**Applicant:** Heyford Park Estates Limited

**Proposal:** Discharge of condition 2 (landscaping scheme) 4 (landscape management plan) 6 (tree pits) of 17/00610/REM

- 2.1. This application seeks to discharge: Condition no.2 (Landscaping Scheme); Condition no.4 (Landscape Management Plan); and, Condition no.6 (Tree Pits) of planning reference 17/00610/REM.

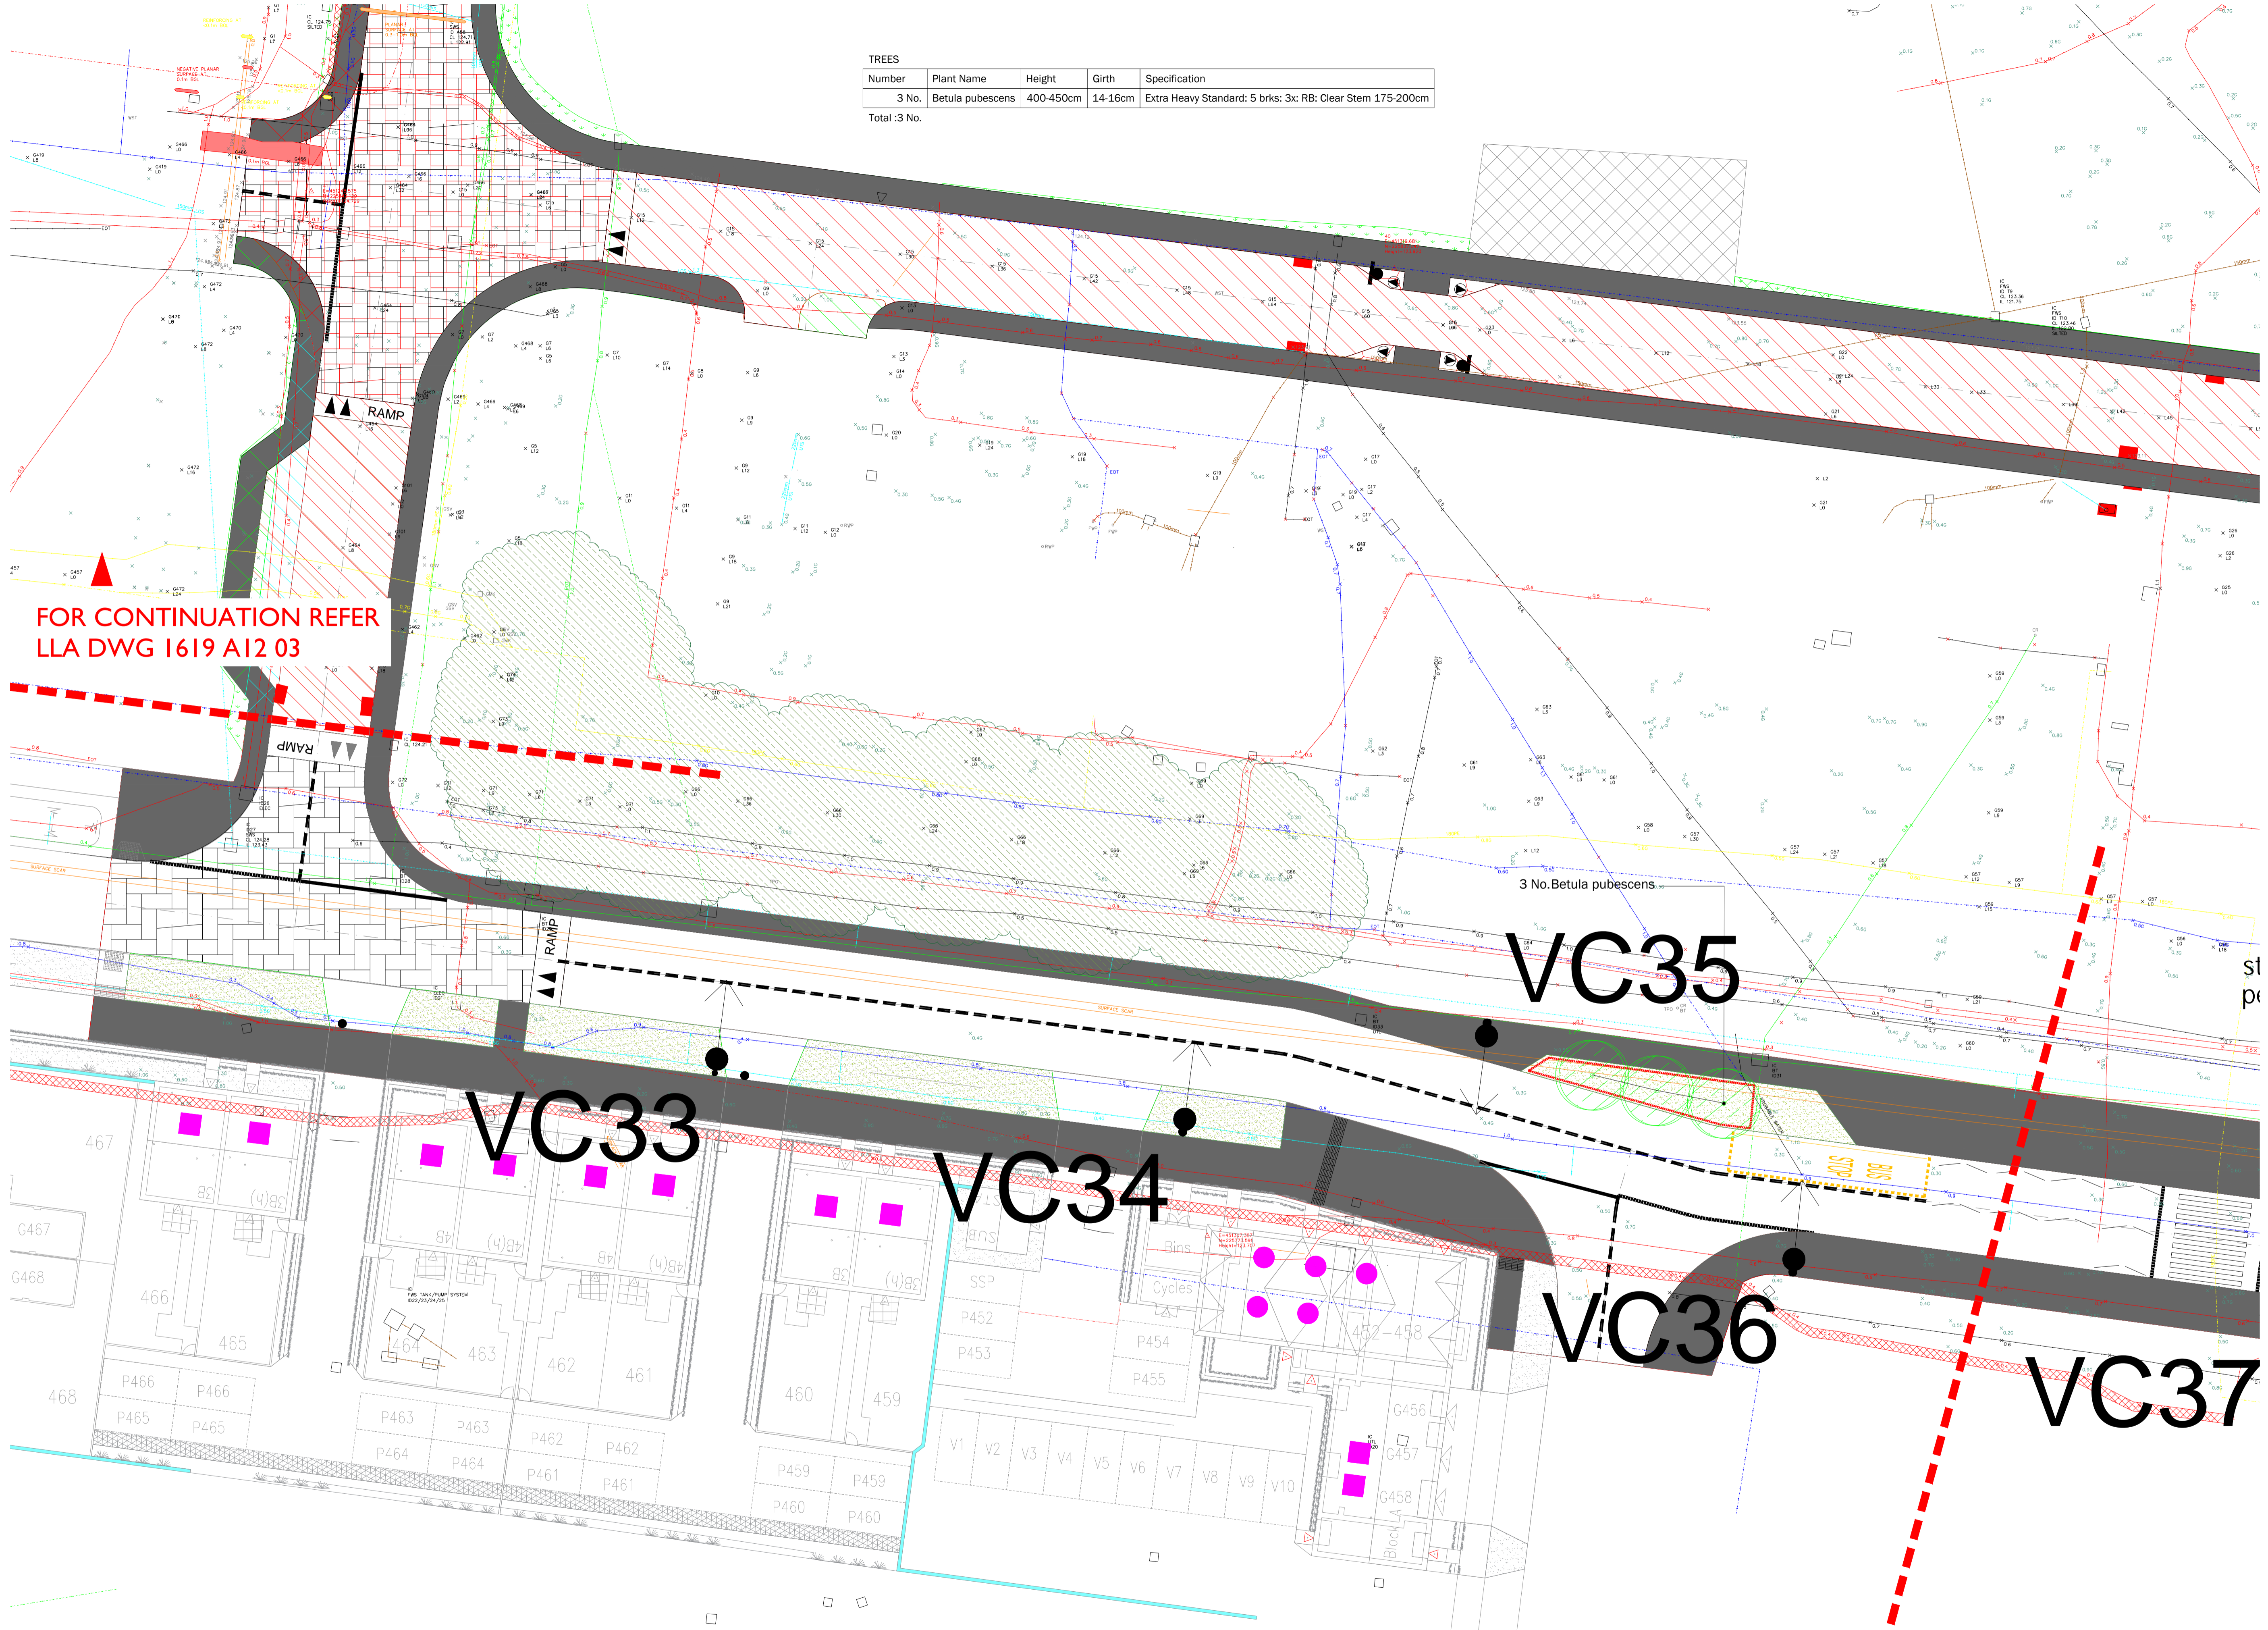
*'regarding the use of Pedula Pubescens on Camp Road immediately adjacent to the bus stop. My main concerns being, Betulas often do not compartmentalise wounds well, therefore may have a decreased longevity as the proposed location will likely mean regular pruning will be required so to prevent interference with the bus stop. Furthermore I have concerns 3 trees within this small grass area may be too dense, potentially causing competition for nutrients/moisture within the soil reducing vitality.*

*Has there been a prior agreement to use Betula Pubescens? If not could I suggest an alternative street tree of a hardy nature, with ideally a thin streetwise canopy that should prevent the need for regular pruning in the future?*
